From: Charlotte Hardy
Sent: 10 October 2017 12:58
To: 'karen jenkins'; Nia Russell; Michael Eastham
Cc: Will Marsh; Arfon Hughes; Reg Kirk
Subject: RE: FRA v4 for BE/102/17/OUT

Subject: FRA v4 for BE/102/17/OUT

Bognor Regis Enterprise

Appendix D – Proposed Drainage Strategy

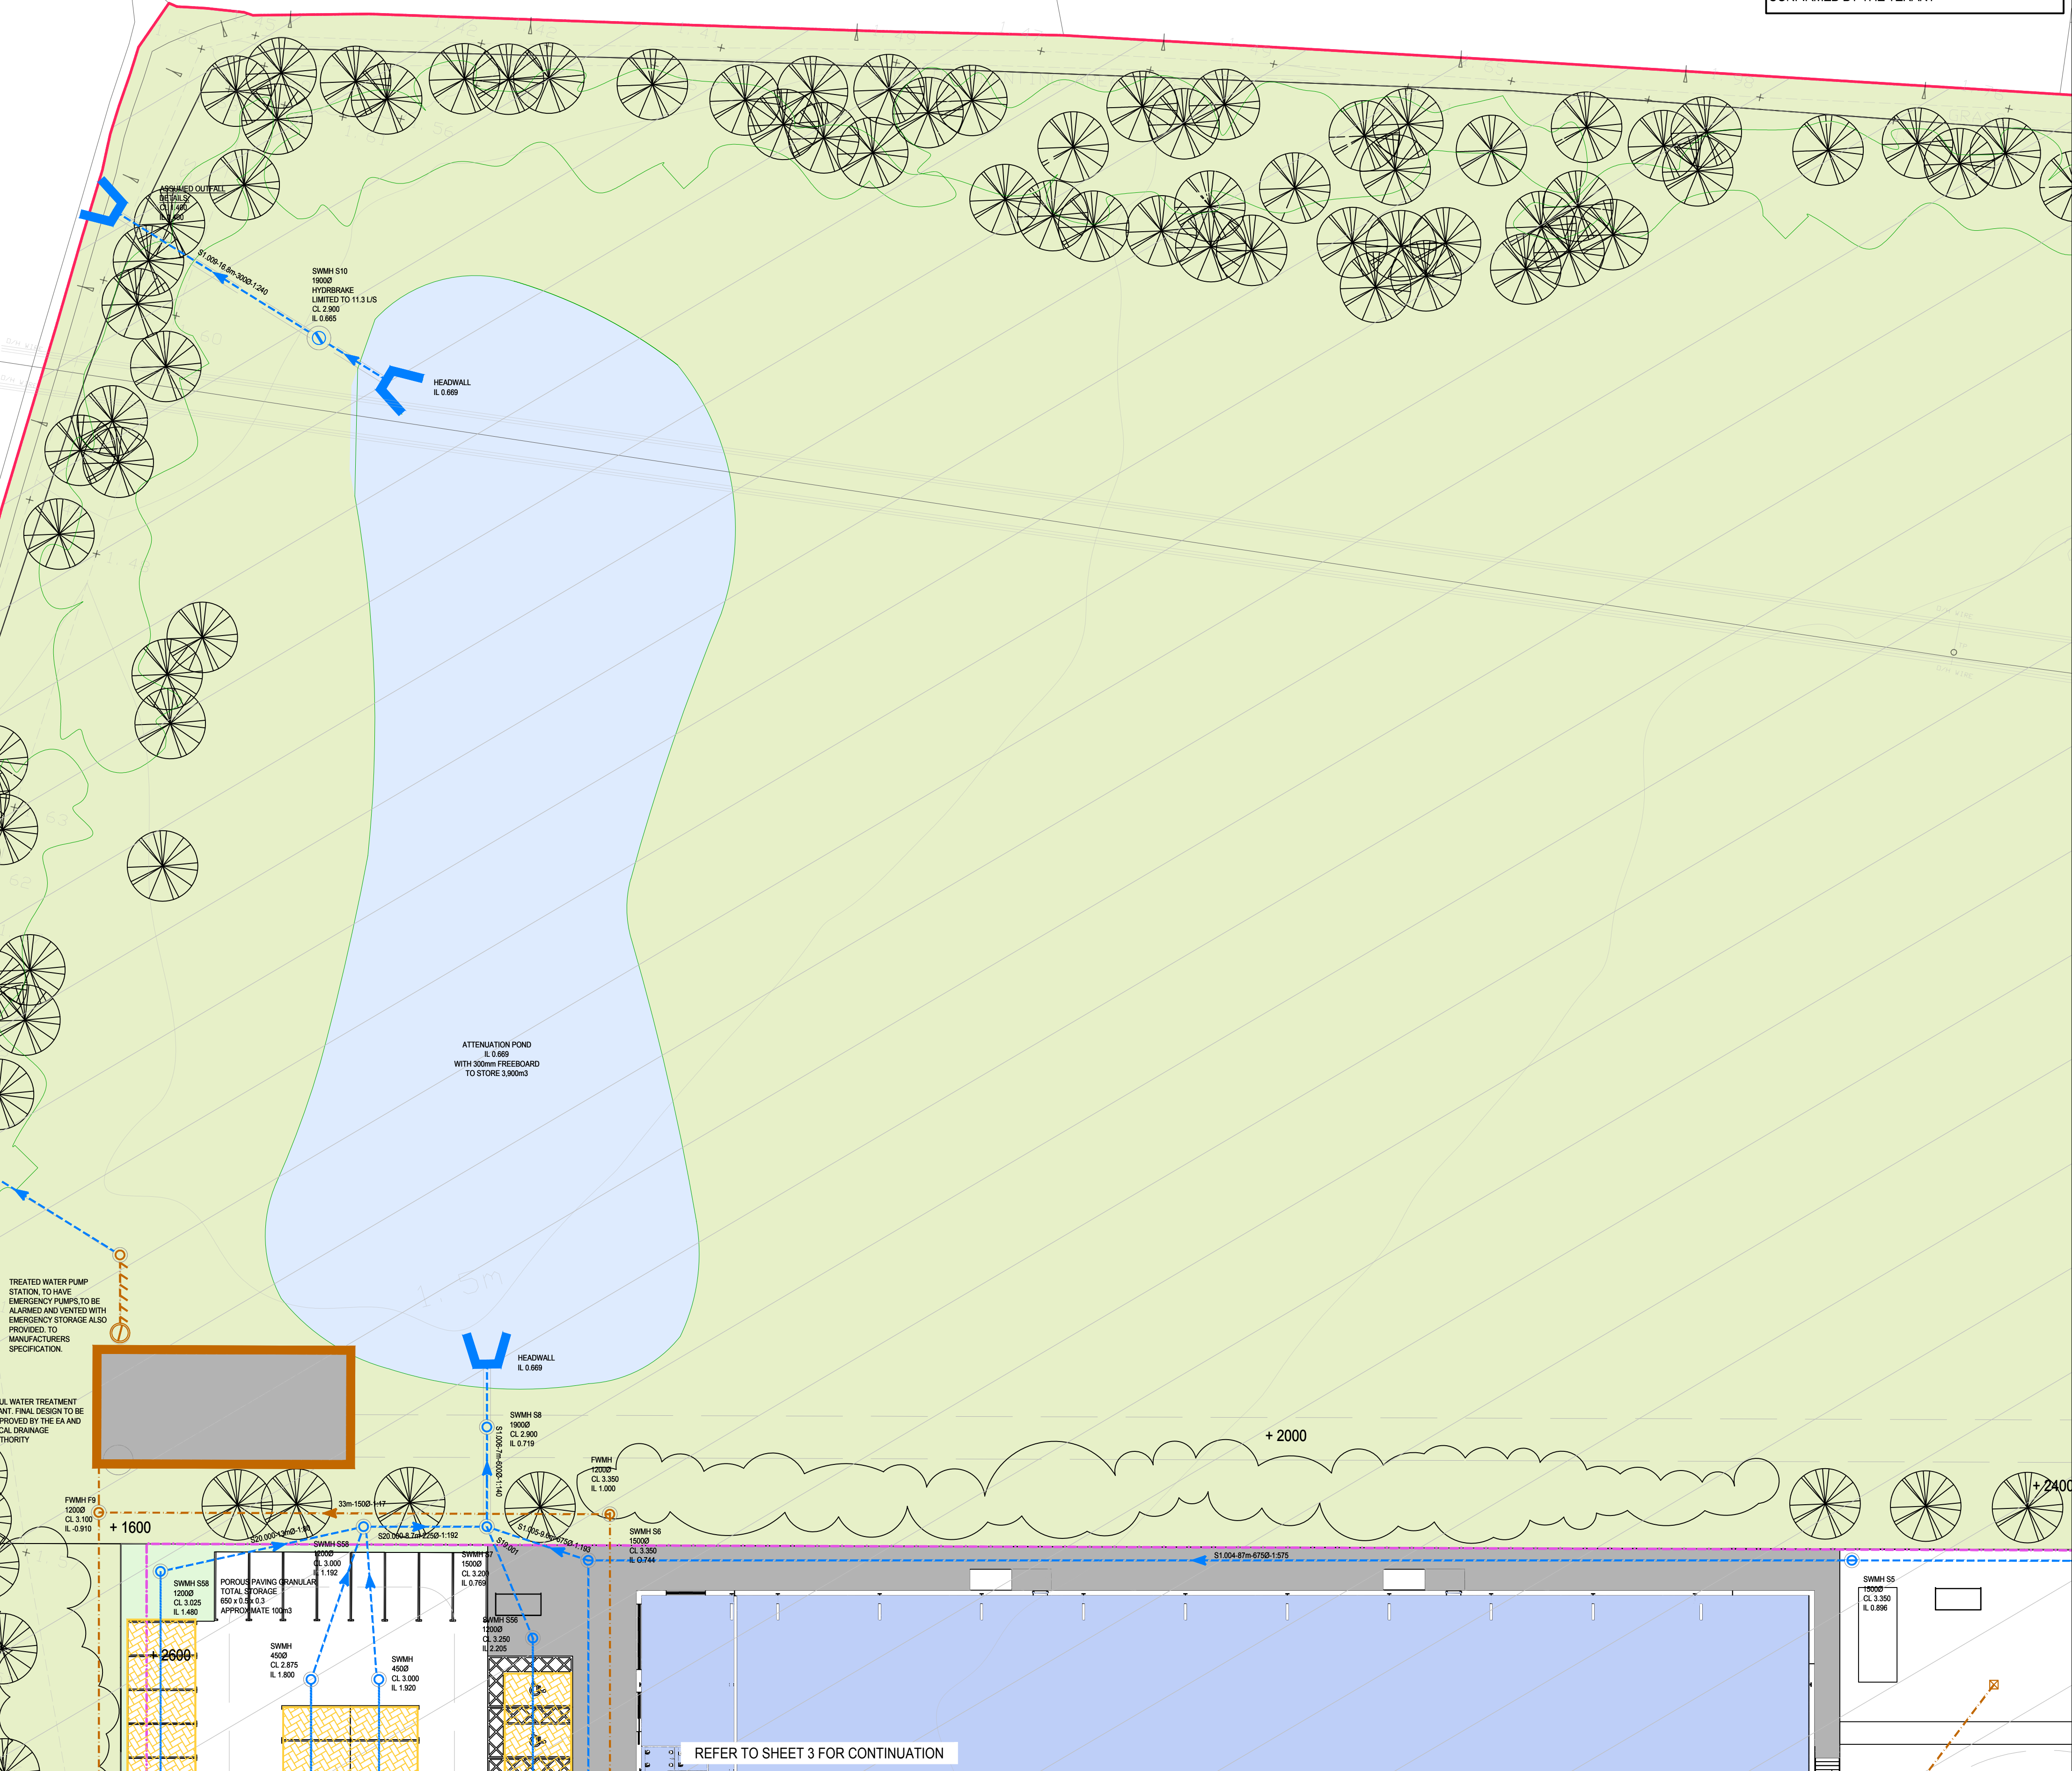
1. Information relating to the groundwater levels across the site
2. The treatment plant, along with the expected connections
3. The survey work of the watercourse and details, for certainty to be gained over the achievability of the gravity connection
4. The achievability of delivering the detention basin as shown in the buffer area considering SSEs plans for the pylons.

- The survey of the watercourse will be carried out shortly and the results are expected in 3 weeks time. We will then update our design to suit the results.

- There is no restriction on SSE on positioning a detention basin under live cables. Providing we ensure safe working practices are maintained whilst the basin is being constructed there is no issue. However the Architect is reviewing the current position in light of your concerns.
